Response to Planning Application

Application ref: CM/14/20/DOC

Description: Approval of details reserved by condition imposed under ref CM/19/17/PL relating to Condition Nos 3 Construction Method Statement & Details, 6 - contamination, 9 - bats, 10 - owl box locations, 11 - nesting cups and & soft landscaping

Location: Kents Yard Brookpit Lane Climping BN17 5QT

LANDSCAPING SCHEME 1:200@A2

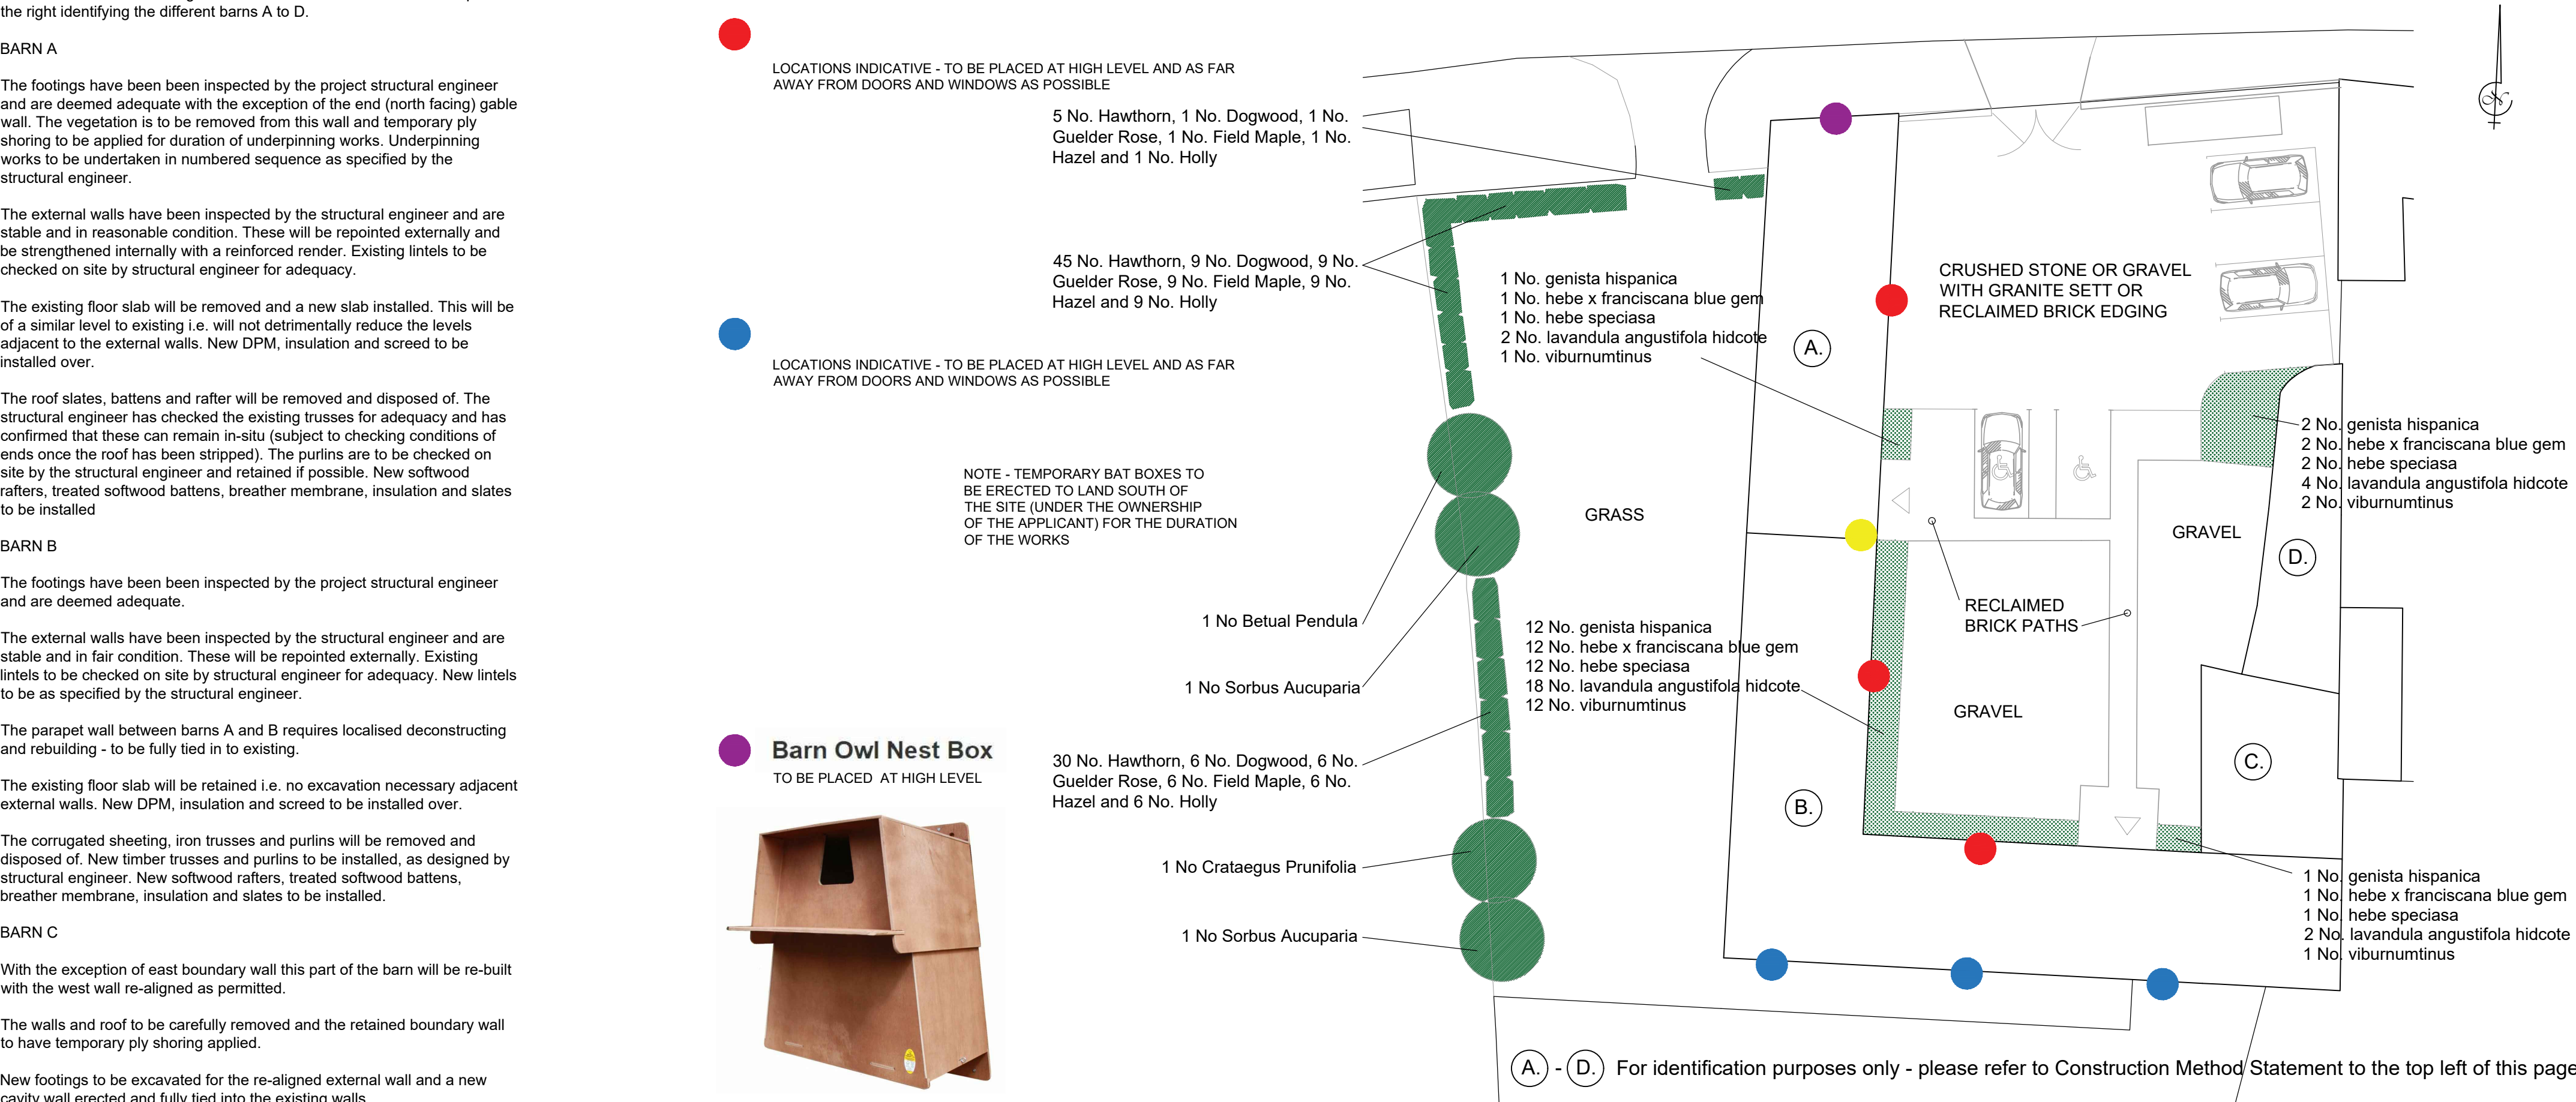
Following submission of Dwg Kents Yard, Climping 1169/Fig 1 rev 03 I can confirm that this does contain a suitable landscape scheme with sufficient plant detail including species type, quantities and size at time of planting, therefore I would **recommend the discharge of Condition 13** Hard and soft landscaping on this application CM/14/20/DOC imposed under CM/19/17/PL
